**Re: Griego Farms at 1860 Griego Rd. NW
Erosion and Sediment Control Plan
Engineer's Stamp Date 4/26/23 (F13E028A)**

Based upon the information provided in your submittal received 4/27/2023, the above-referenced ESC Plan cannot be approved until the following comments are addressed.

Temporary Erosion and Sediment Control Plan

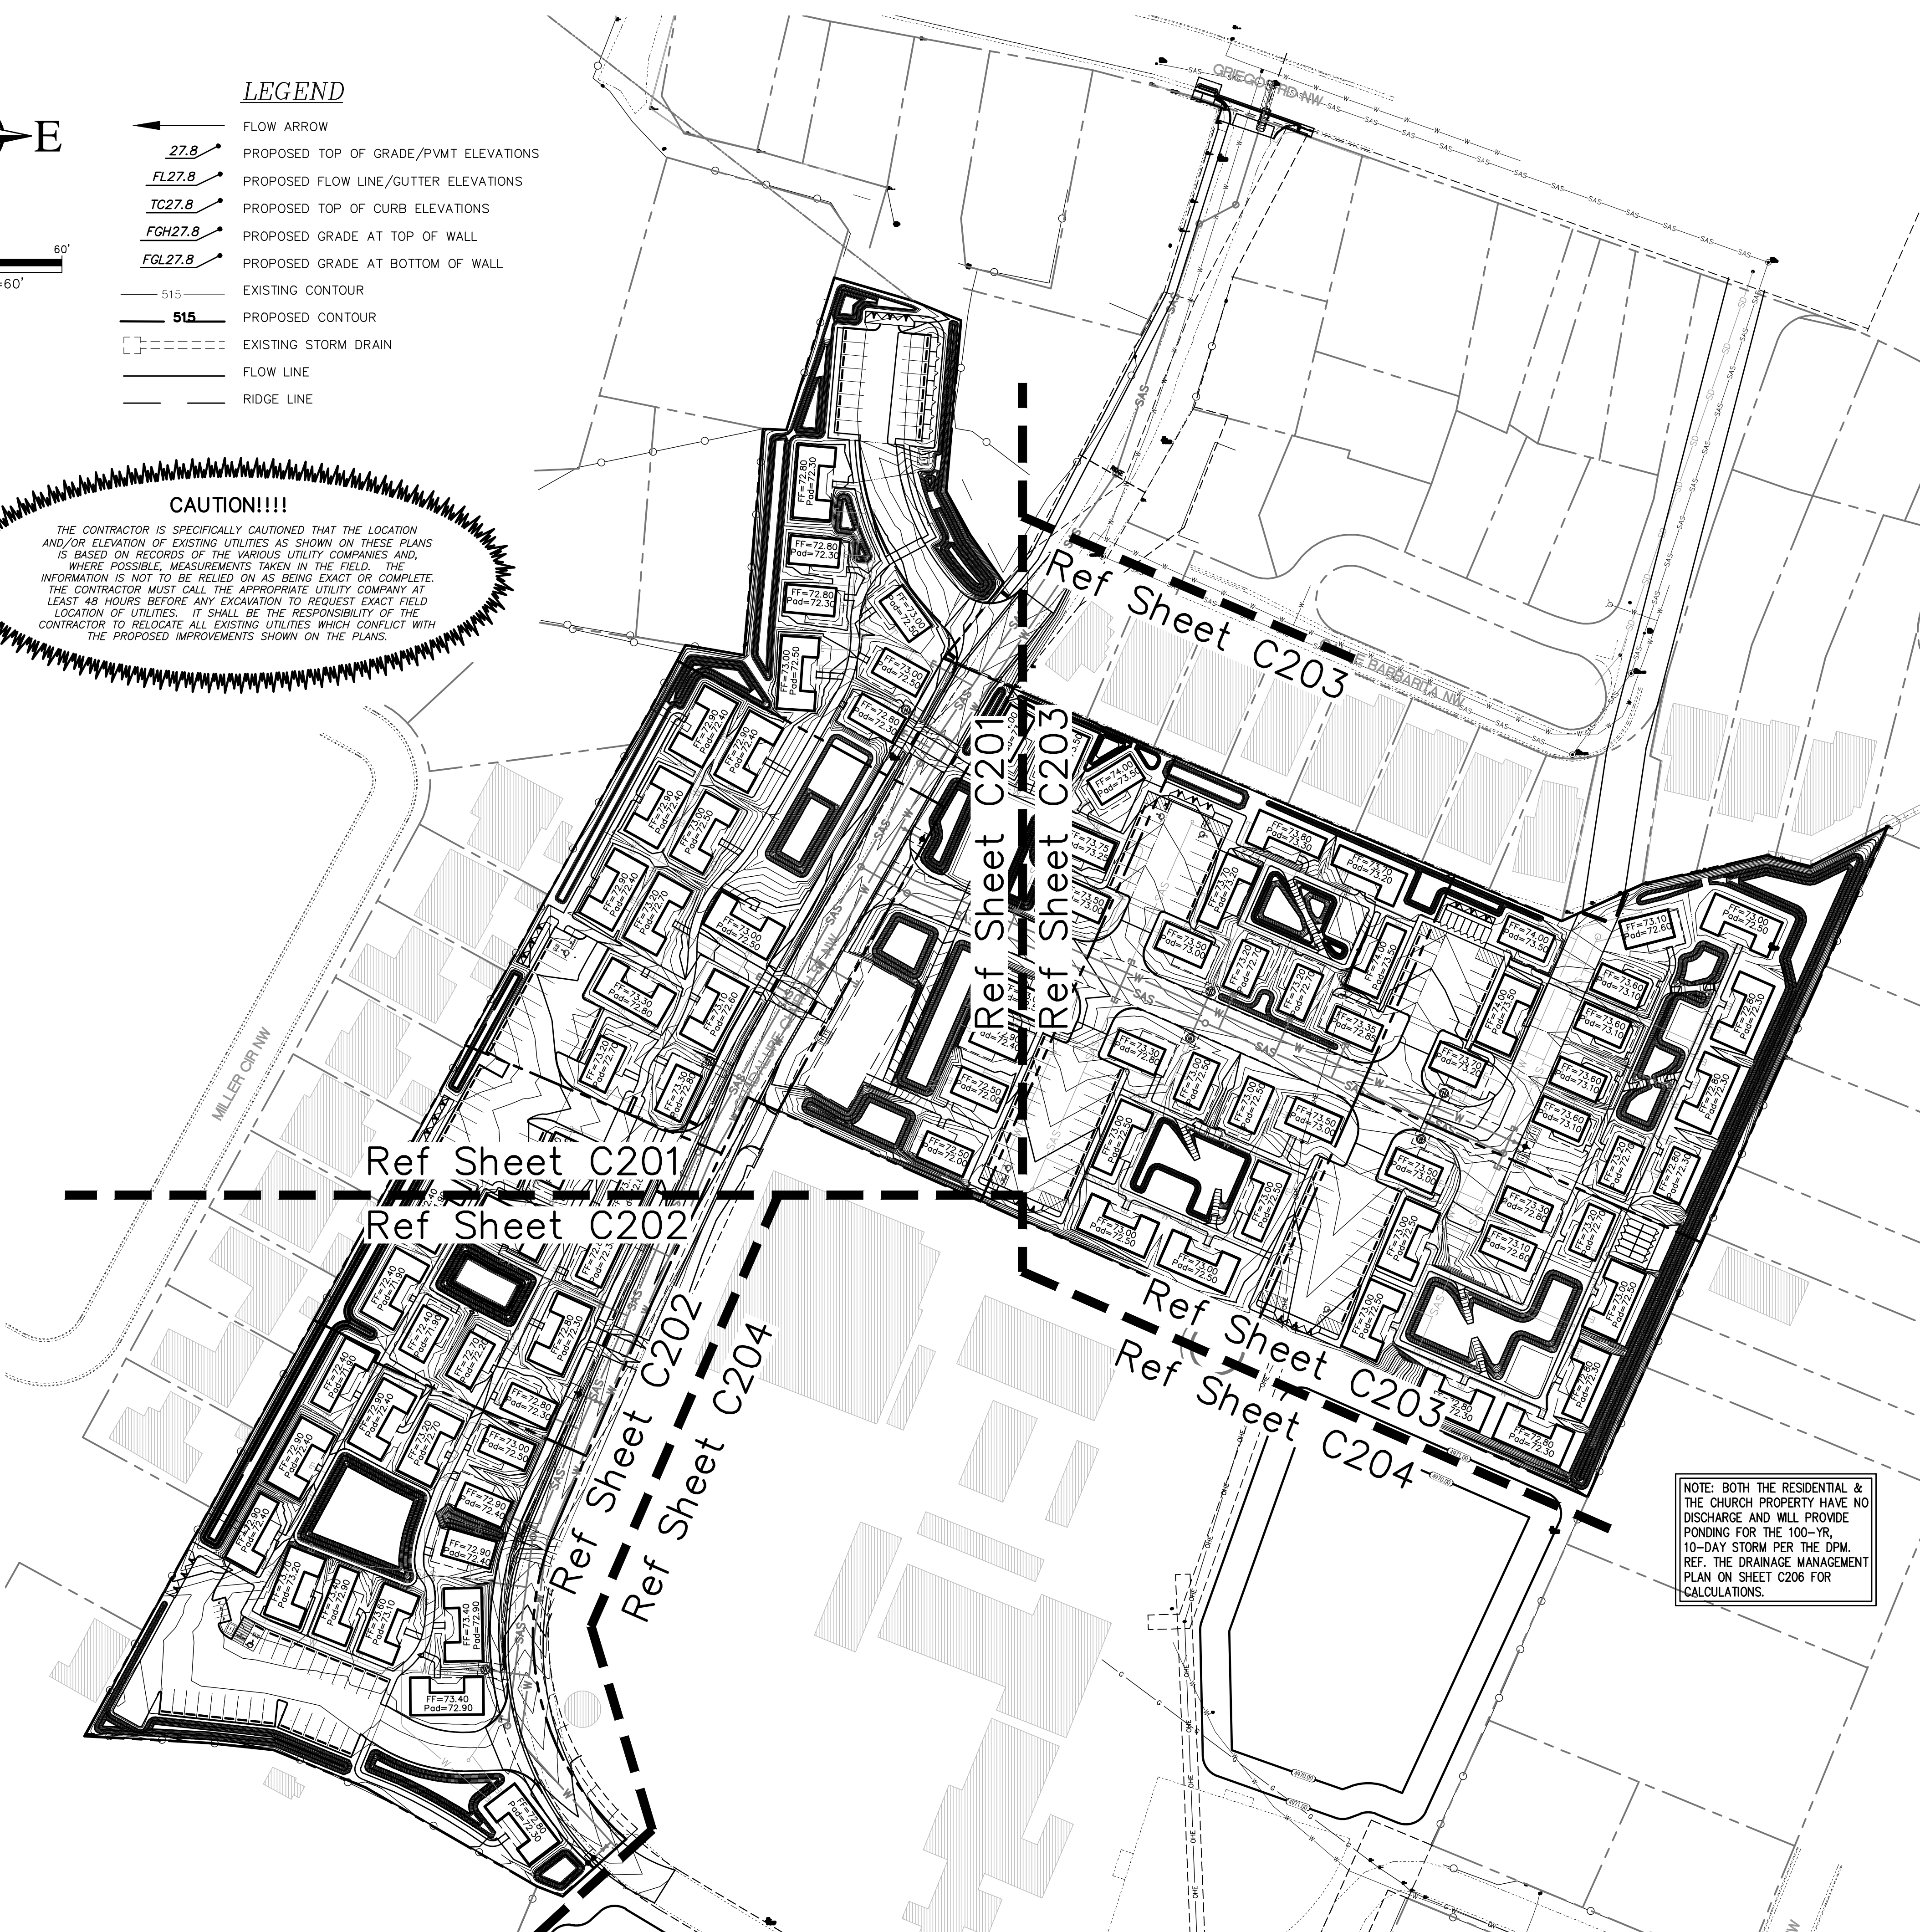
1. Each sheet must be 24" x 36" with a title block and a professional's certification. There were only two sheets included in the 4/27/23 submittal that were both stamped and that contained information that is required on the ESC Plan Checklist, but addition sheets and/or information may be required. Number each sheet in the plan set Sheet 1 of 2, Sheet 2 of 2, etc., so that a person looking at any one sheet will know how many other sheets are included in the plan set. Include a sheet legend on the first sheet, and the City's Standard ESC Notes (attached) on one of the sheets in the plan set.

2. More detail is needed. The ESC Plan must clearly show the location of the boundary and all property lines. Property lines are not identified in the legend. What are the lines on the G&D Plan that use the line type typically used to indicate property lines. Label all lots with the legal lot number. The grades shown on the approved G&D Plan must be shown on the ESC Plan so use the sheets in the G&D Plan that show the grades as the base for the ESC Plan.

4. I can't tell the difference between building, sidewalk, asphalt, and dirt on the ESC Plan. These structures must be clearly identified in the SWPPP per CGP 7.2.4.b.vi. The same information is required in the ESC Application. You may attach a copy of the Site Plan to both the SWPPP and the ESC Application to address this requirement.
5. The SWPPP must include site-specific interim and permanent stabilization per CGP 9.4.1.c.i. The Landscape Plan can be used to satisfy this requirement and should be submitted separate from the ESC Plan with the application to the Stormwater Quality Section of the Planning Department and it should be included in the SWPPP. Provide a specification on the ESC Plan for any disturbed areas not covered by the Landscape Plan.
6. Update the engineer's stamp date each time the plan is changed.
